From: DataSpace Consult [dev.admin@resolutiondm.com]
Sent: 15 October 2009 12:51
To: Planning
Subject: Comments Added: 11 SOUTH DRIVE, CUFFLEY

Application ID: S6/2009/1737/FP - Ms B Matawski Application Owner: Welwyn & Hatfield Borough Council (Development Control Officer)

Location: 11 SOUTH DRIVE, CUFFLEY

Description: ERECTION OF SINGLE STOREY REAR EXTENSION WITH GABLE ROOF, LOFT COVERION WITH SIDE DORMER & PARTIAL FRONT GABLE CONVERSION

PROPOSED
GF PLAN 1:50

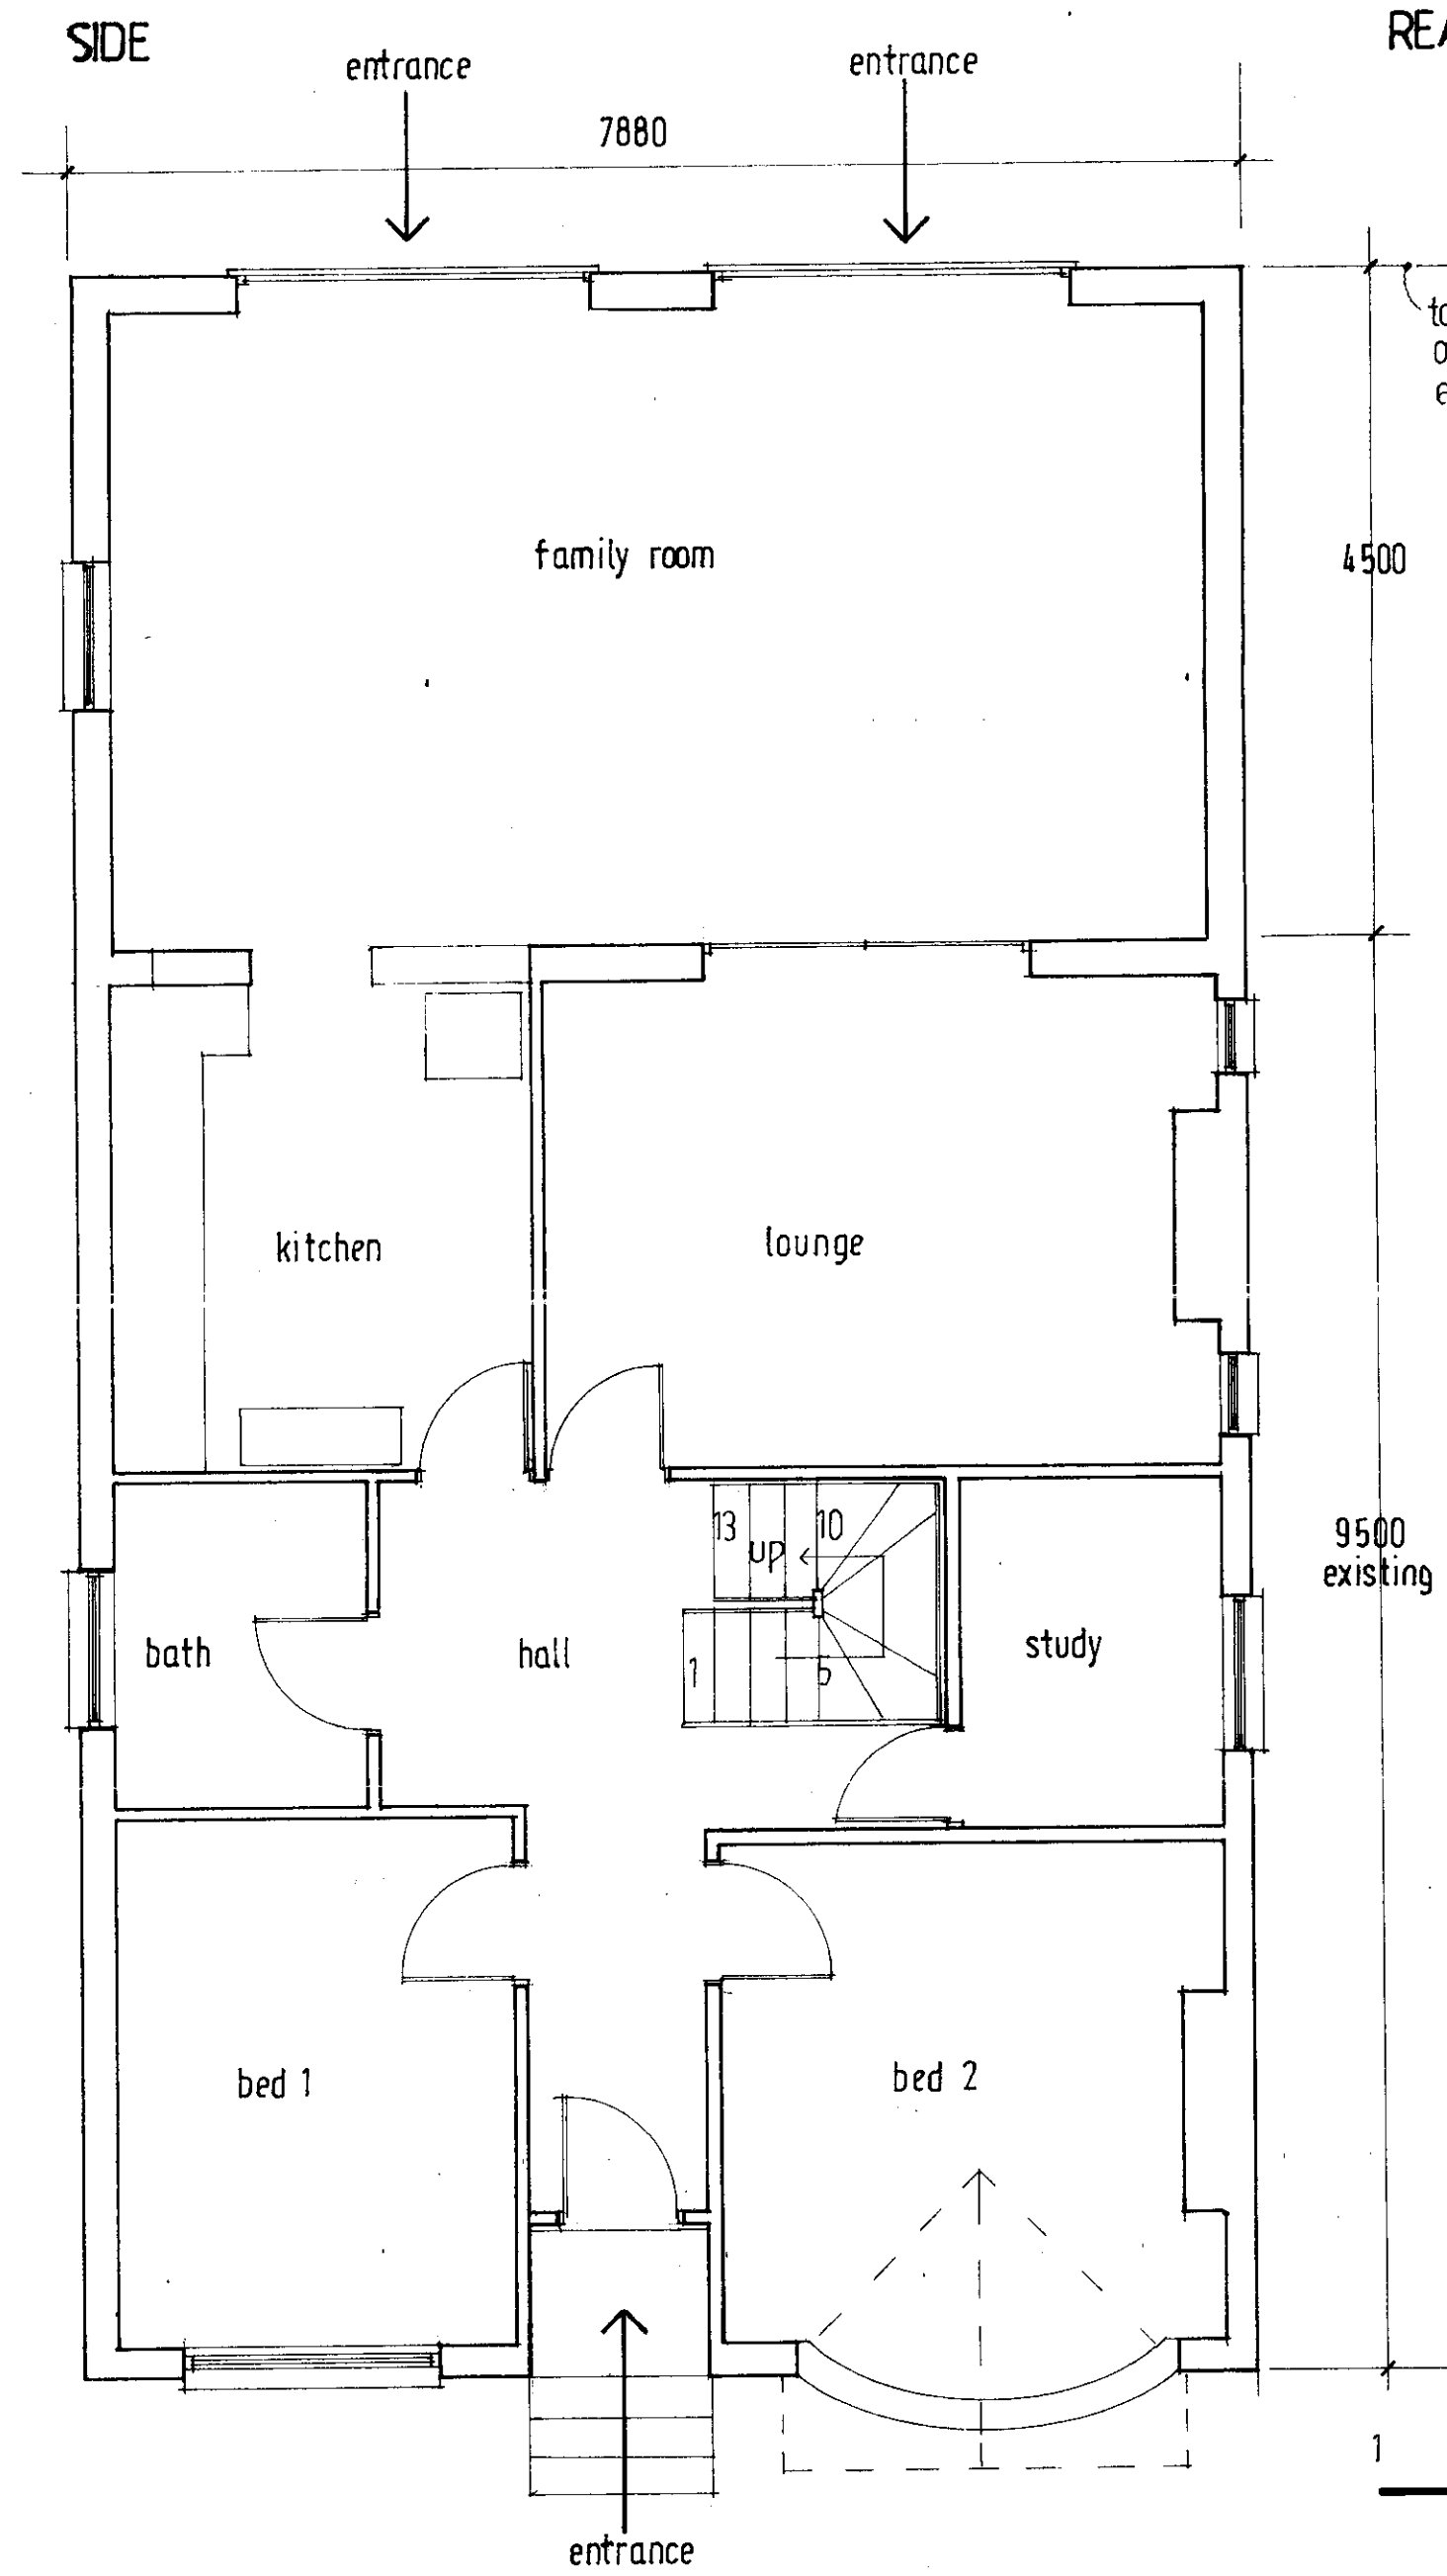
Comment: OBJECTION: It appears the applicant is intending to build partly over a shared driveway which would create some difficulty of access and egress for all parties. The driveway is a right of way. There is also an issue of overlooking and loss of privacy due to the provision at first floor level of a balcony and French doors.
